# CITY OF ALBUQUERQUE

**Re: Pando Daycare**  
**3504-3506 Anderson Ave SE**  
**30-Day Temporary Certificate of Occupancy**  
**Transportation Development Final Inspection**  
Engineer's/Architect's Stamp dated 10-21-19 (L16D041)  
Certification dated 7-21-20

C4 BIKE RACK
1/2" = 1'-0"

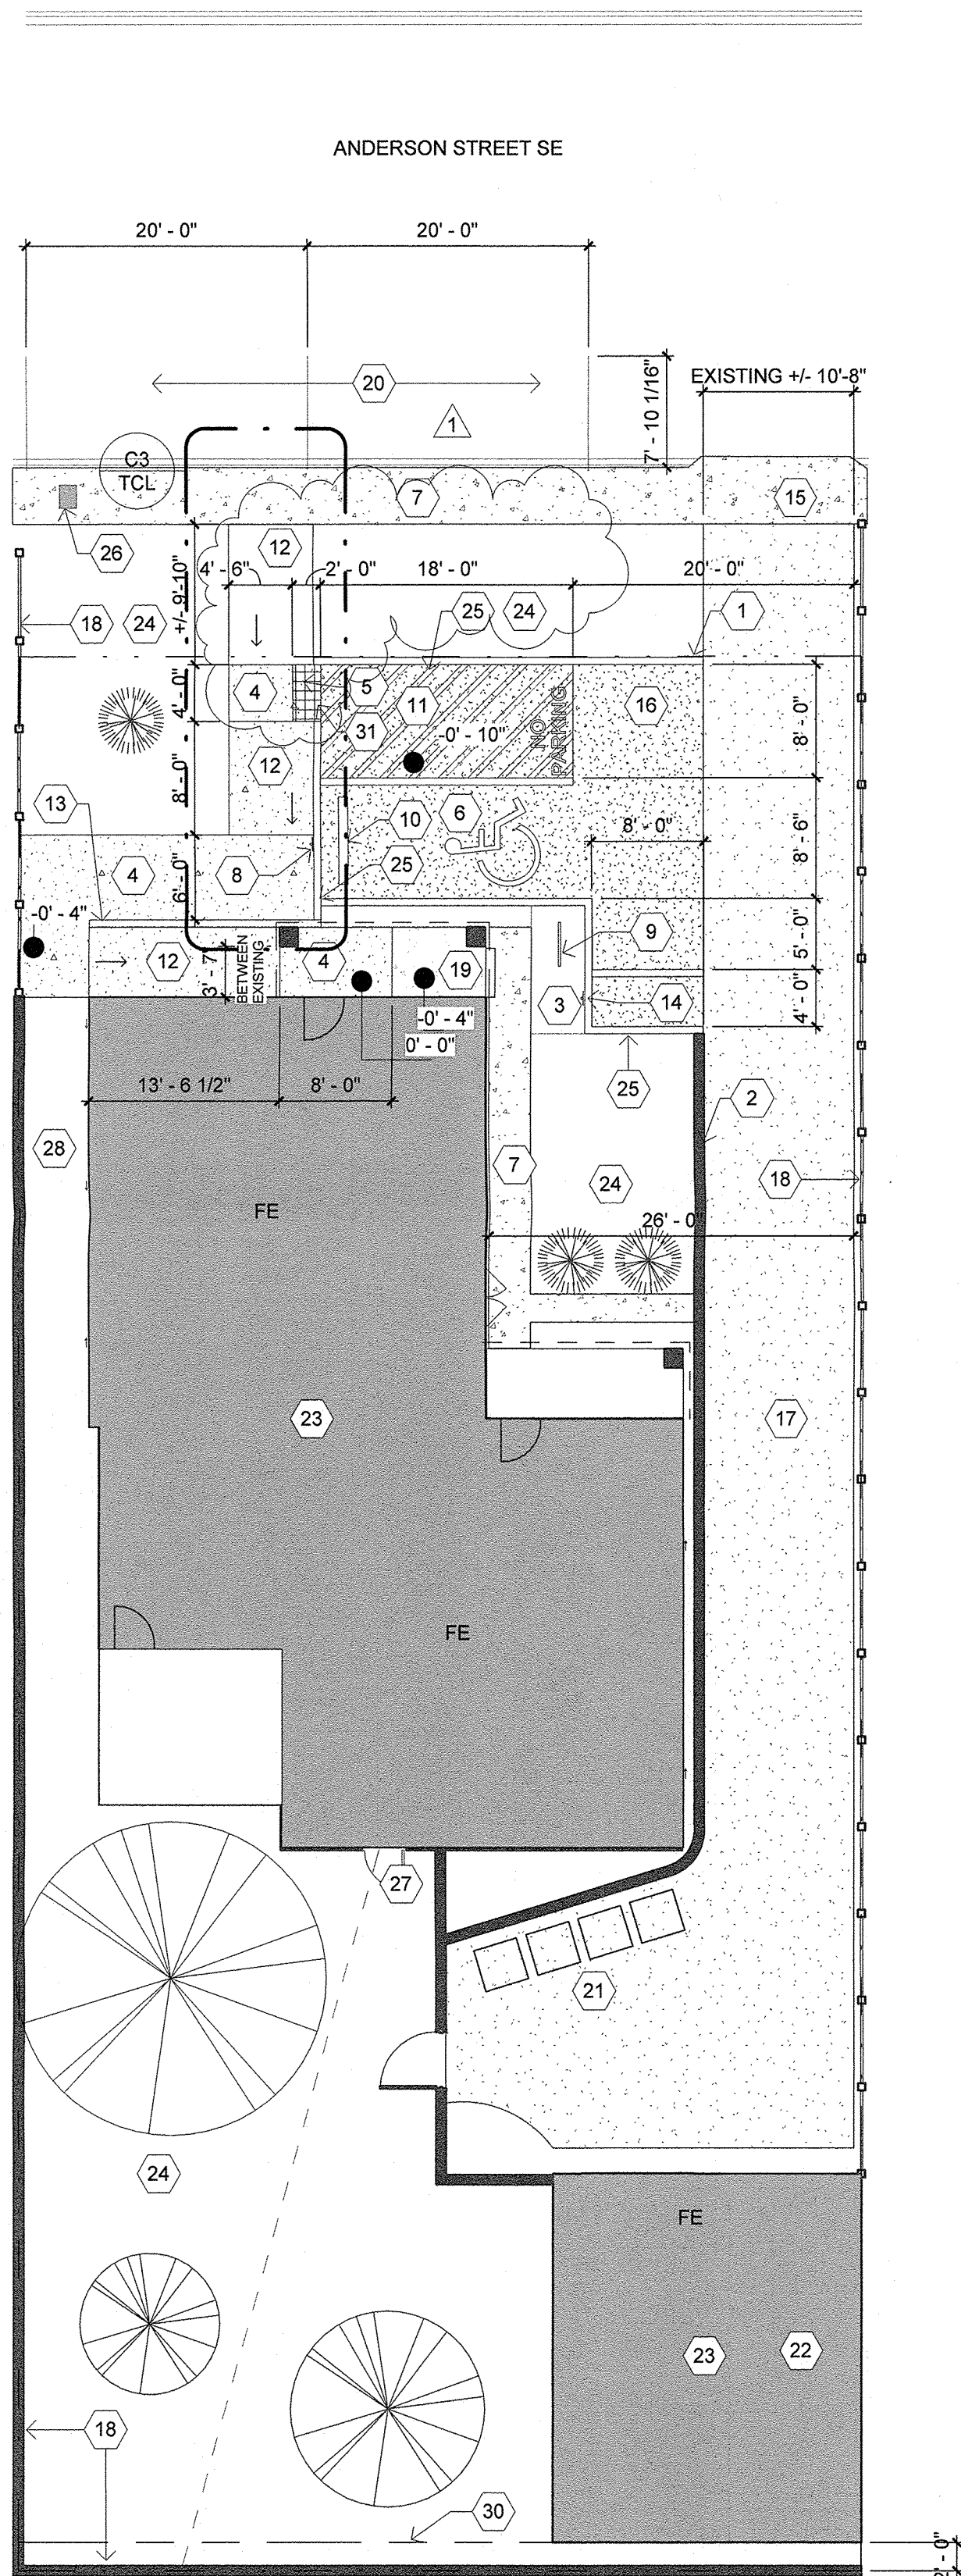
- Please add Bike Rack.
